Application Ref:	3/2025/0172			 <div>Ribble Valley Borough Council</div> <hr/> <div>www.ribblevalley.gov.uk</div>
Date Inspected:	11/06/2025 & 16/07/2025	Site Notice:	11/06/2025	
Officer:	MC			
DELEGATED ITEM FILE REPORT:				
				APPROVAL

Development Description:	Proposed installation of air source heat pump to rear with acoustic screen.
Site Address/Location:	20 Old Hive, Fish House Lane, Chipping, PR3 2QQ

Proposed Elevation (Scale 1:100)

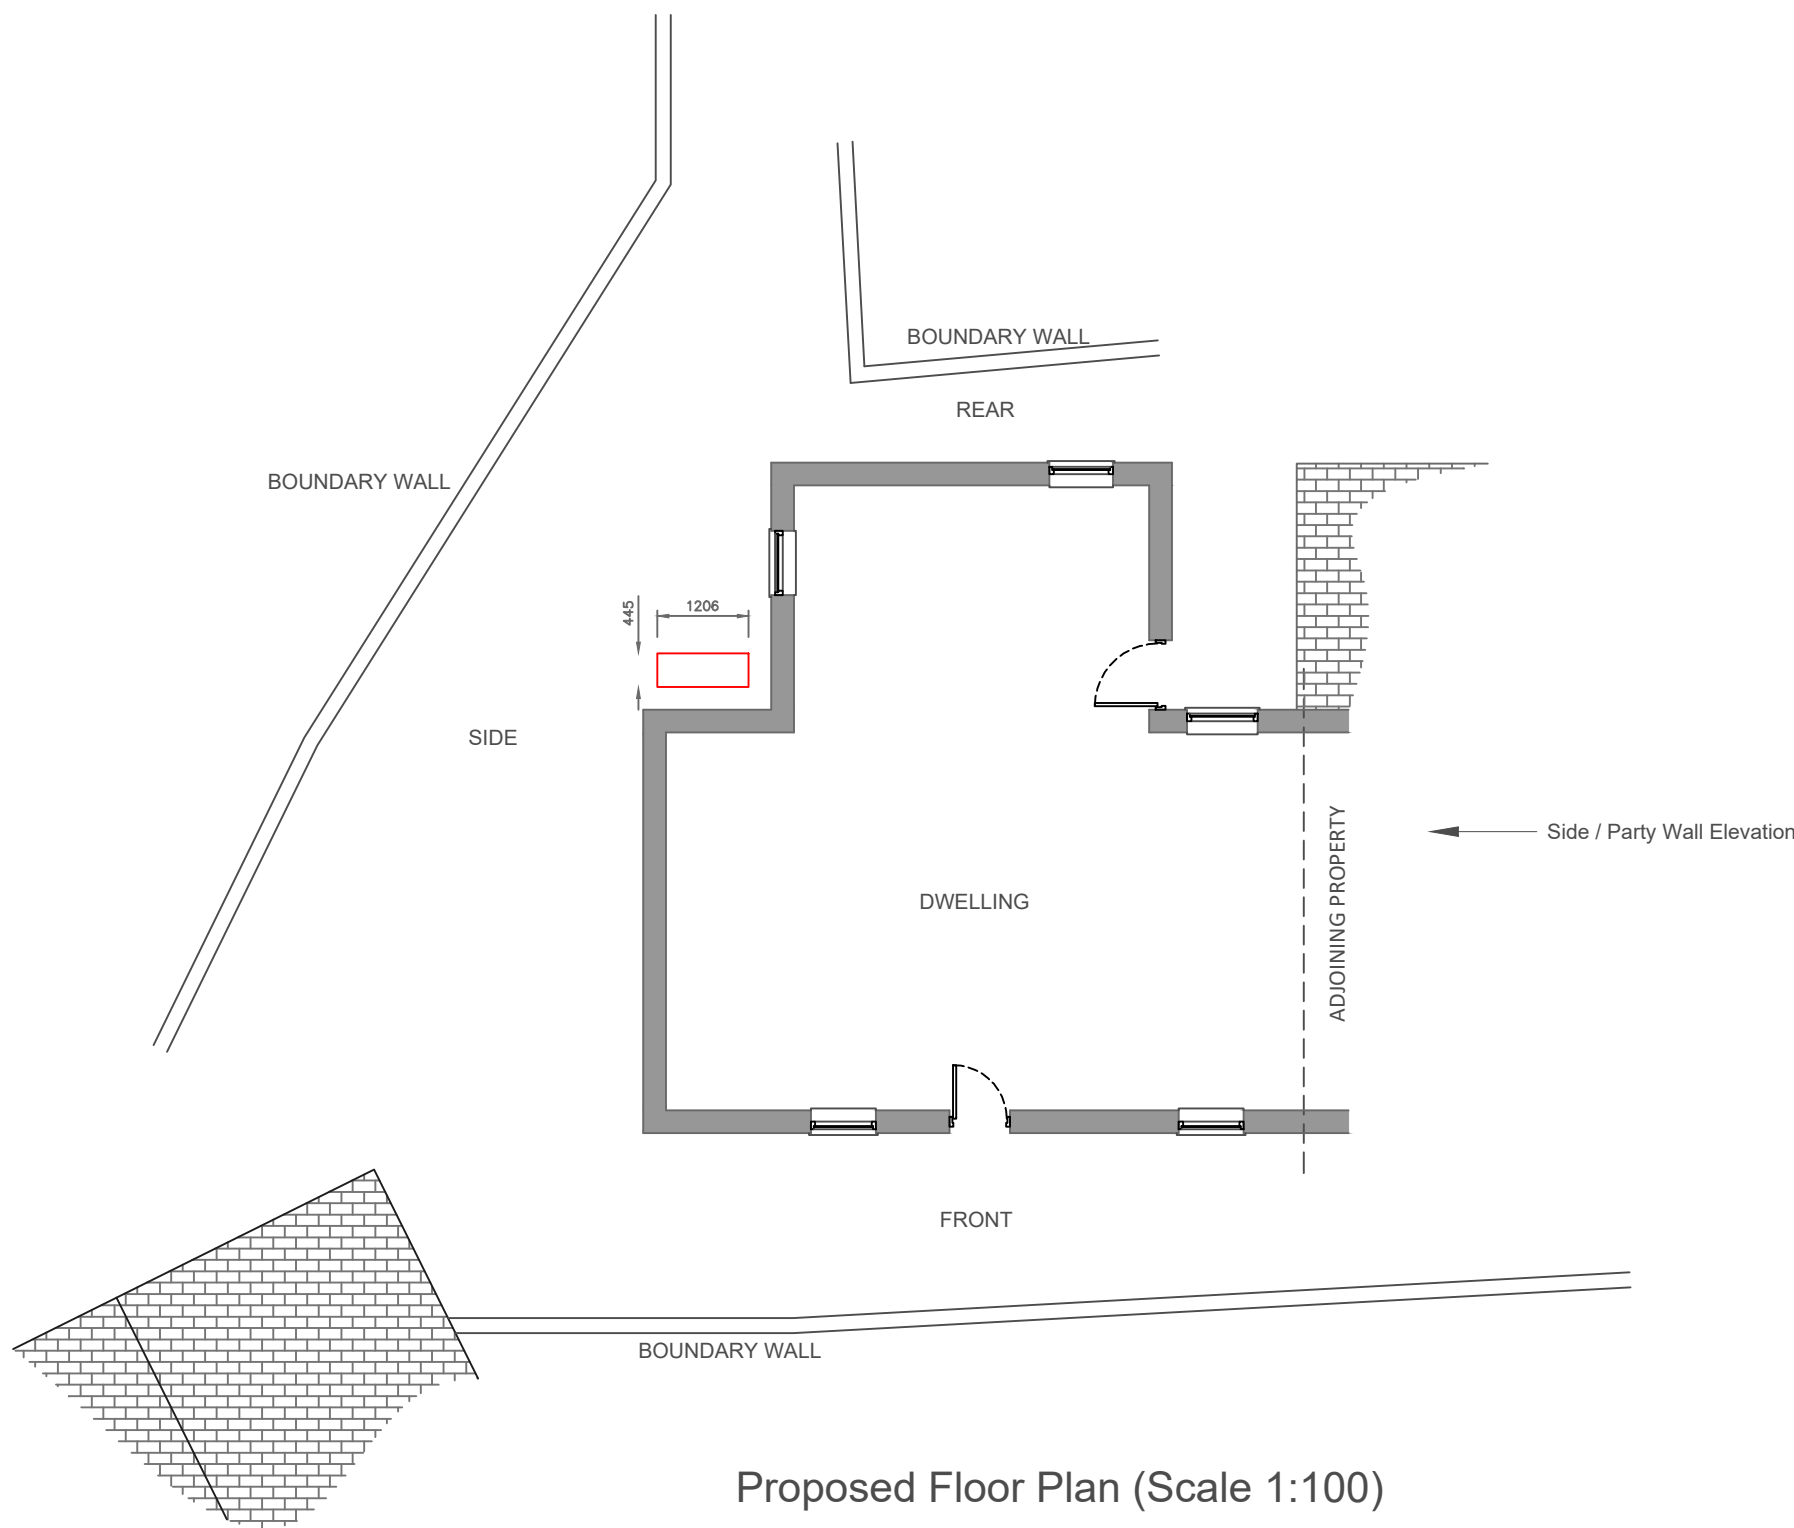
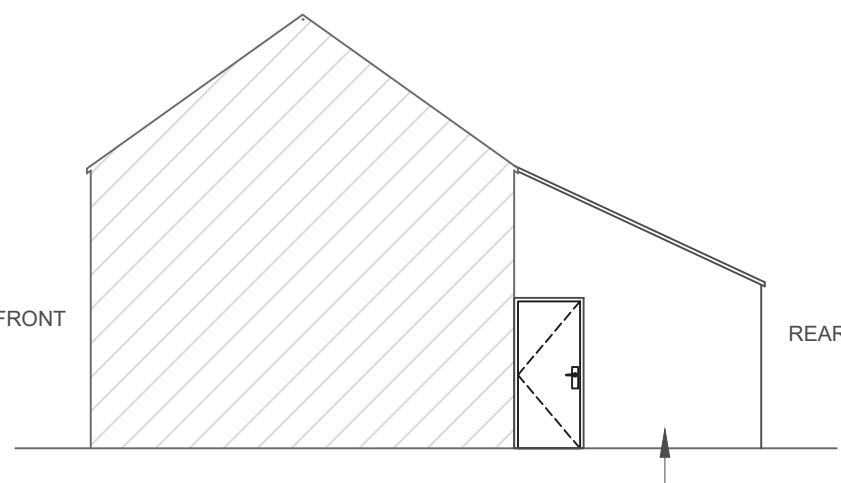
An acoustic barrier has now been included within the application. This is shown on the amended elevation plan to be Jacksons absorptive fencing and would be installed to the side elevation, to screen unit. The fencing would be 1.2m h x 1.2m wide.

Proposed Site Plan (Scale 1:200)

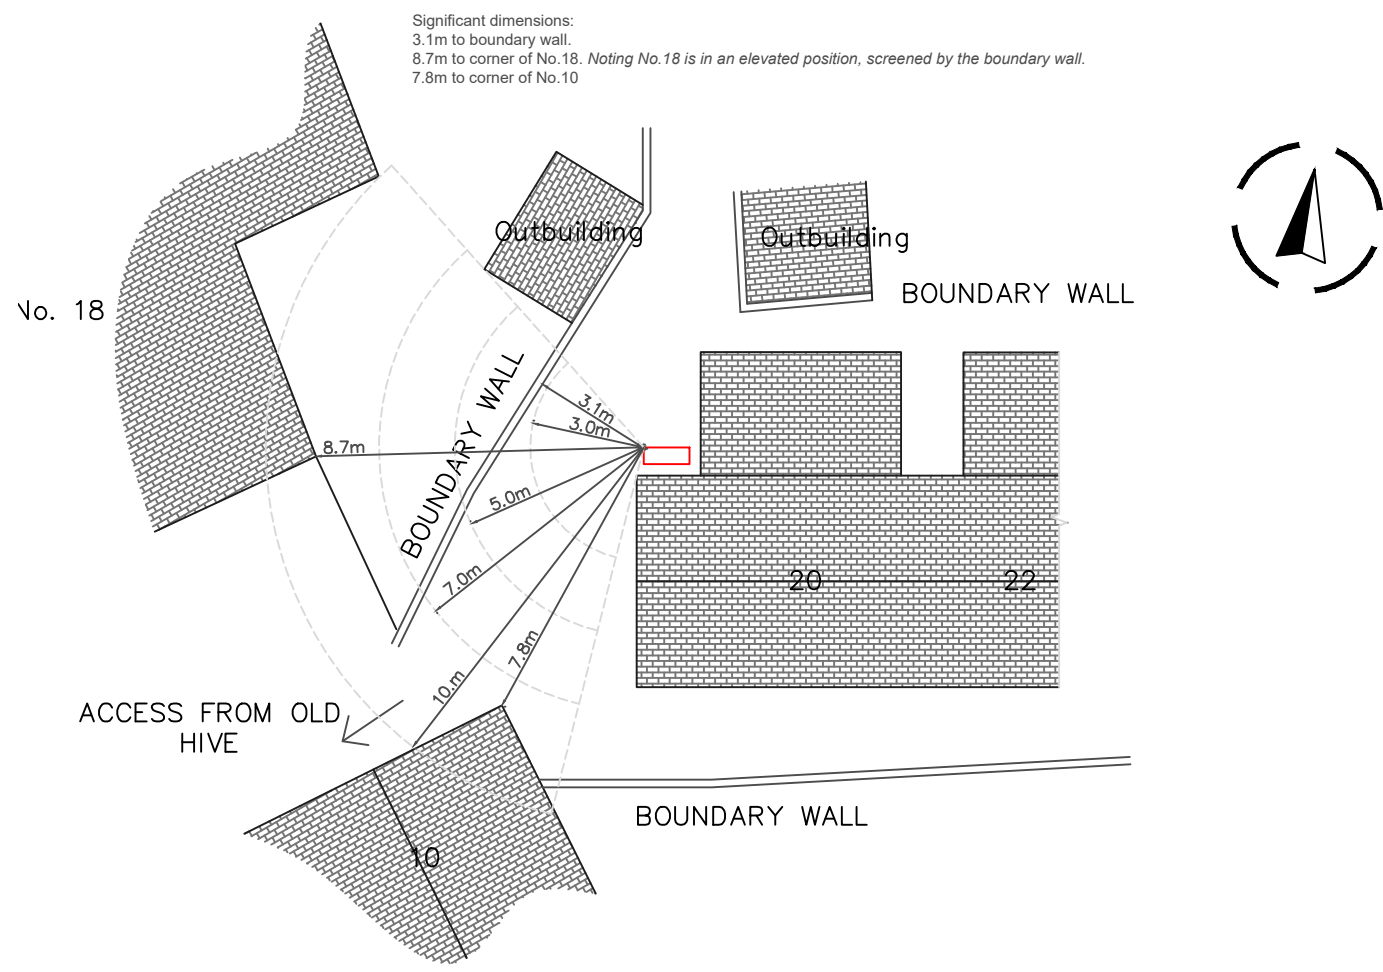
Consent is sought for the installation of a Global Energy Systems Rothesay Air Source Heat Pump located to the rear elevation of the application property, along the northern wall. The proposed heat pump would measure 0.9m in height, 1.2m in width and 0.4m in depth and would be sited approximately 3.1 metres from the eastern boundary wall at its closest point.

They consider that if implemented, the proposal would result in detrimental noise disturbance due to the specification of the proposed air source pump and the close proximity to the neighbouring residential receptor, being visible from the first-floor side facing window.

It is considered that the acoustic screen would help mitigate any harmful noise effects and would block the line of sight from this first-floor window.

Subject to the implementation of the absorptive screen prior to first use of the heat pump, the proposal is considered acceptable with respect to impact upon residential amenity.
